Our reference: ECM Ref: 9733734  
Contact: Gavin Cherry  
Telephone: (02) 4732 8125

13 October 2021

**Response to Request for Advice: SSD-18204994 Snack Brands  
Manufacturing Facility at 14 Distribution Drive, Orchard Hills**

Drawing Title:
Landscape Plan
DWG No:

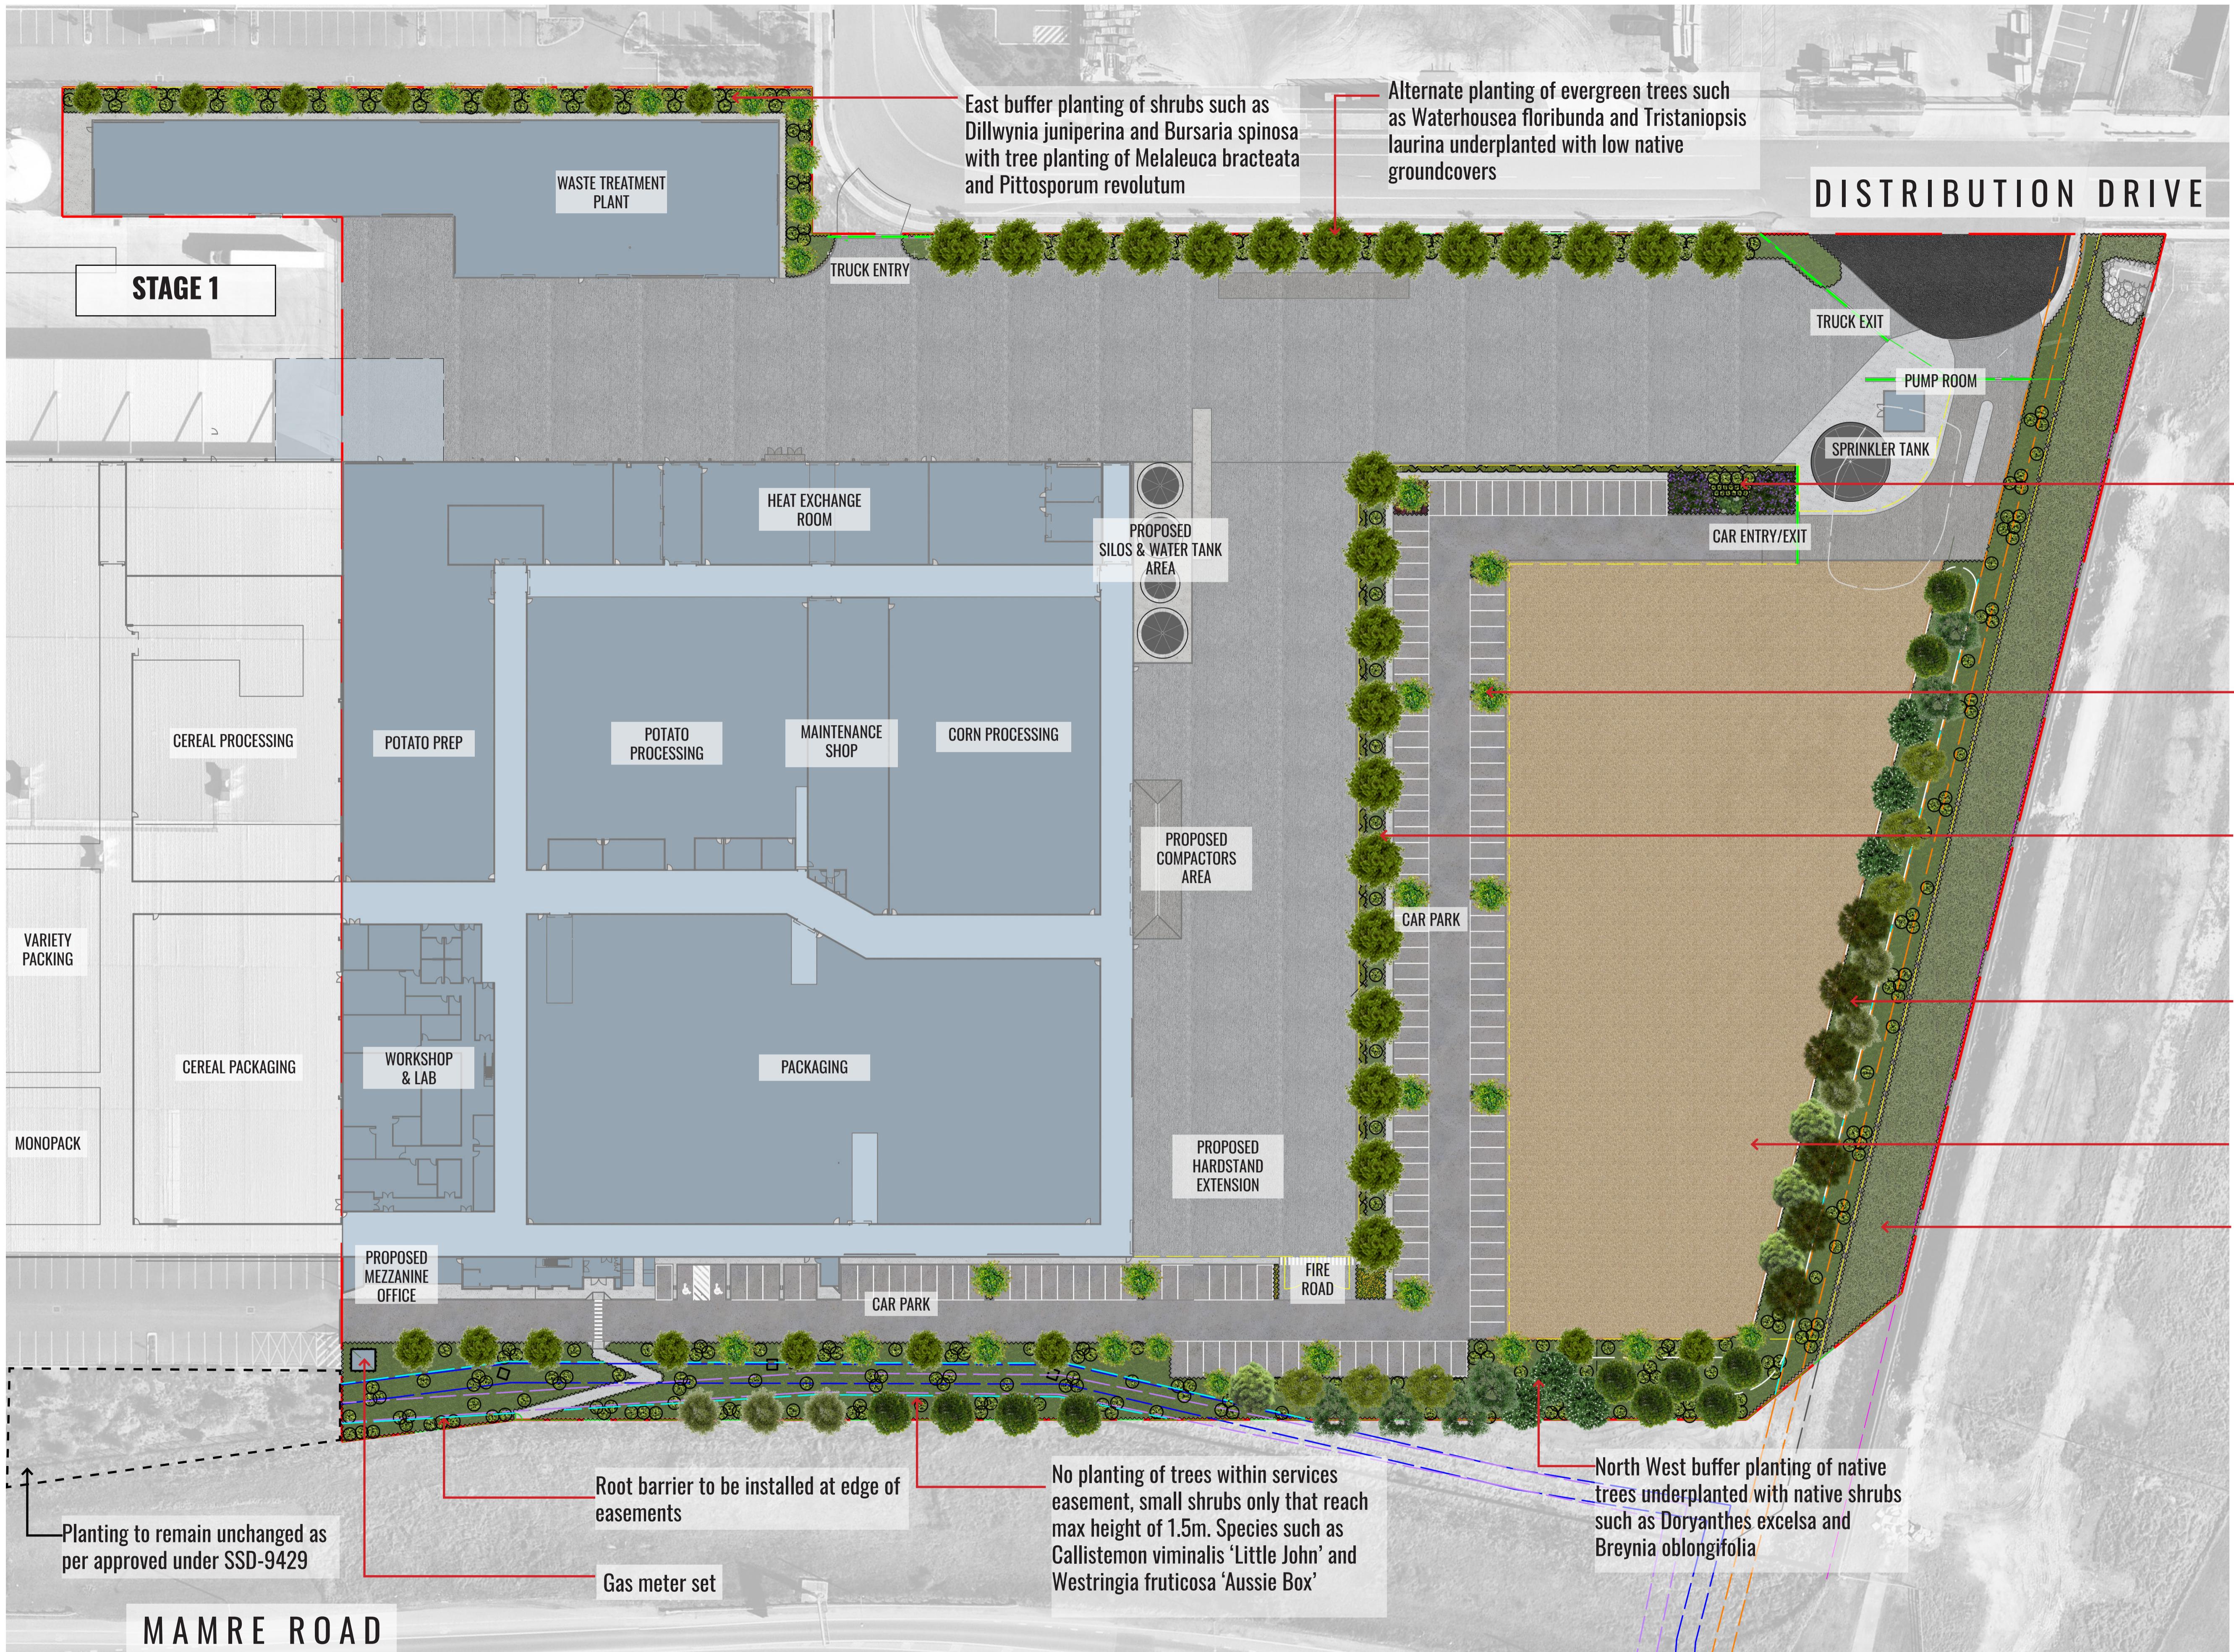
The landscape plans depict tree planting within the car park however the trees should be offset / staggered across both sides of the aisle to maximise canopy

cover and shading opportunities in accordance with Council's Cooling the City Strategy. The current tree planting arrangement in the car park will not sufficiently assist to ameliorate the abundance of exposed hard stand parking on the site. The same offset principle should also be applied between the single trees in the parking area and the trees within the landscape strip between the parking area and the hardstand extension opposite the proposed compactors area. With the exception of one location, the trees are planted adjacent to each other which is a poor arrangement.

The landscape strips for tree planting in the car park are also inadequate in size and dimension. A minimum of 2m width (if not greater) is required whereas the landscape design plan suggest only 1.0m (or less) is provided. This inadequate to achieve the canopy coverage required to meet the objectives of the car park tree planting requirements. This will necessitate further reduction in car parking to address these requirements. The resulting car parking numbers achievable would need to be reconsidered against the projected demand within the Traffic and Parking Assessment and if there is a shortage, redesign to accommodate the required parking would be expected.

- This area should be visually separated from the carpark with a garden bed that provides vegetated screening and shade planting, and reduces the visual impact of the 2m high palisade fence.
- The extent of compacted aggregate finish to the parking area is considerable. A number of islands planted with large canopy trees and WSUD should be investigated to reduce heat generation. Pedestrian access from this carpark should also be considered and depicted (noting comments above regarding relocated and overflow parking).
- Section BB demonstrates truck parking will be visible from the public domain and Mamre Rd. Dense screening is required meaning trees and groundcovers must be supplemented with dense shrub plantings that will achieve a size so that the full height of trucks cannot be seen from surrounding areas, as per DCP objectives.

- Increases to the diversity and density (decreased spacings) of trees to the perimeter edges of all carpark areas is considered necessary to achieve DCP objectives.

2 MASS PLANTING AND TREE DETAIL

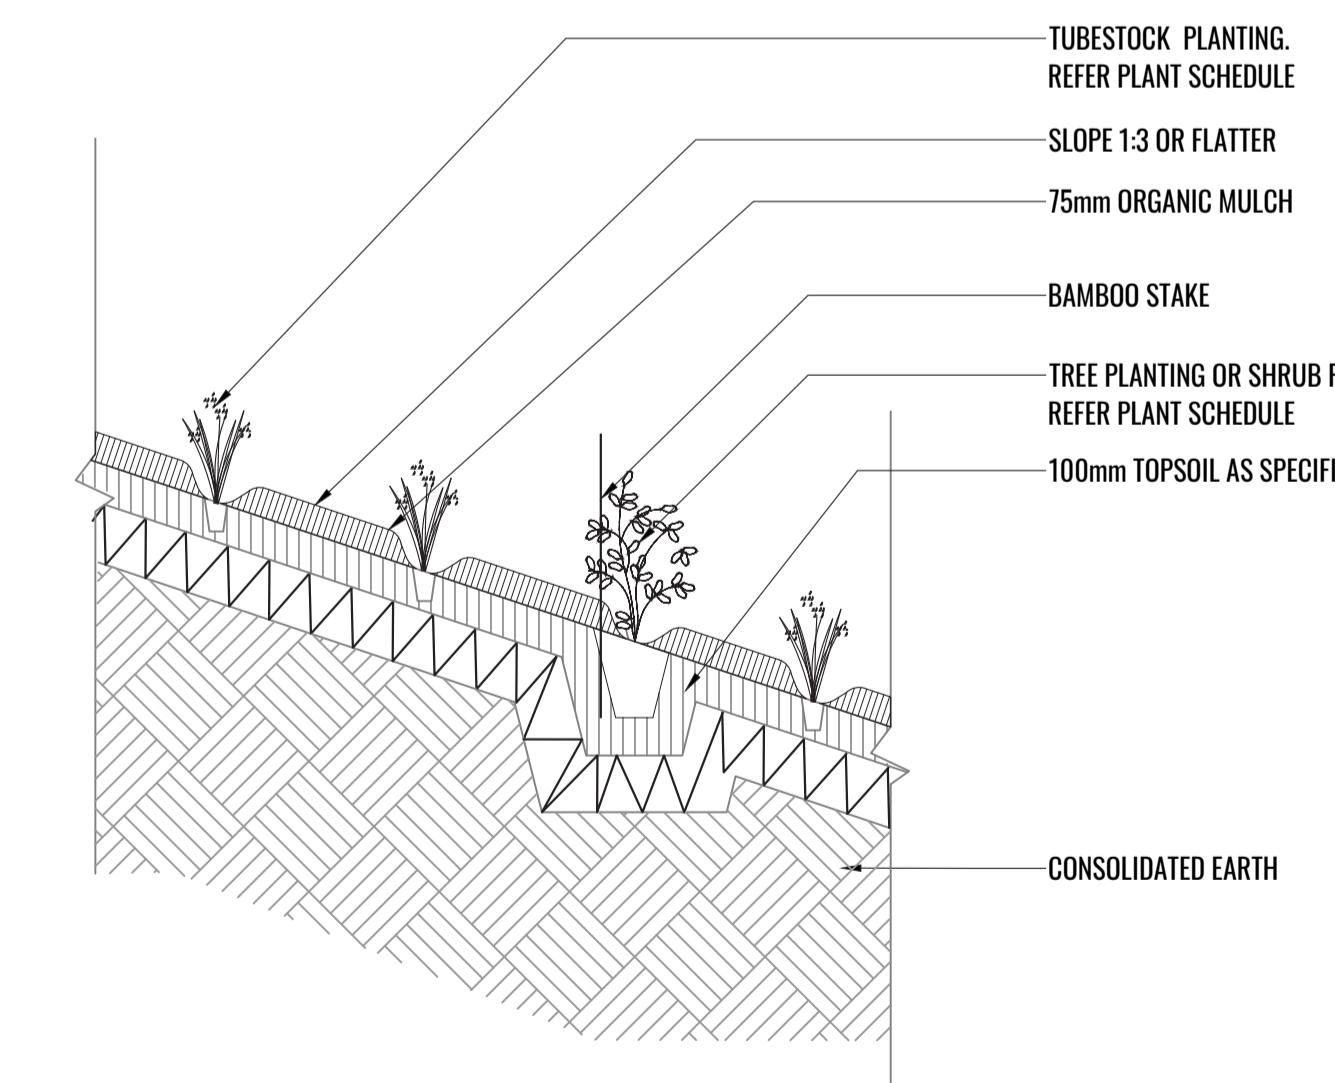
- A carpark tree planting detail has not been provided. The tree pits should also be engineered (eg. Stratavault system, structural soil etc) to sustain rootzones noting comments above for wider landscape beds. Canopy cover in the carpark is also minimal and larger species should be considered in tandem with larger tree pits.
